From: Neil Cox [REDACTED]
Sent: 06 November 2018 14:23
To: Zac Denton
Subject: Re: EP/127/18/HH - Request for further information

Drawing Name
Location and Block Plans
Proposed

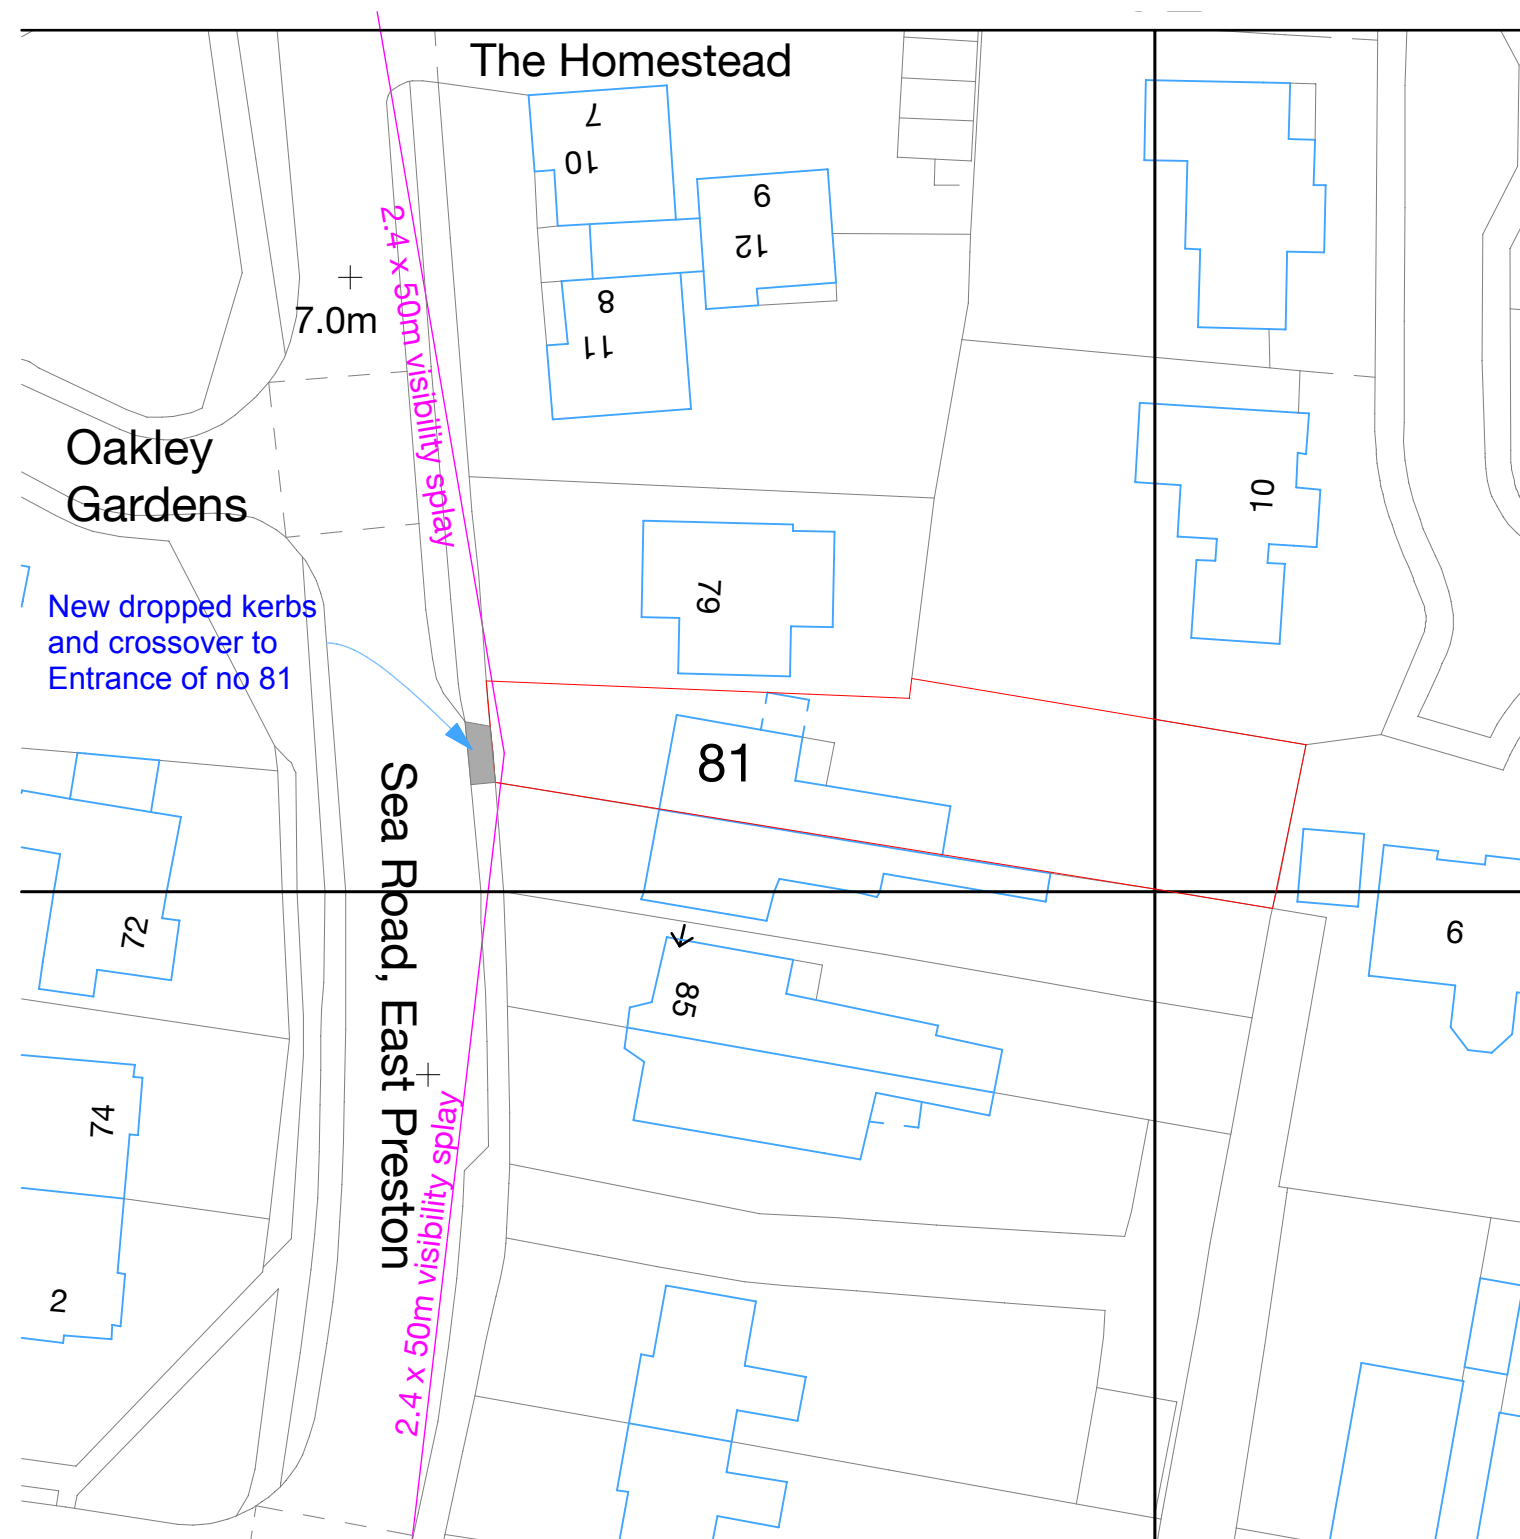
Further to our phone conversation earlier, please provide details/plans specifying details of what you are proposing to do with the front boundary wall during this application.

My intention is to remove the wall on the right of the existing gate, keeping the all the existing brick posts. I will then use the flints to fill the gap where the gate is. The width of the new wall will be approximately 2.1m and the driveway opening approximately 3.85m.
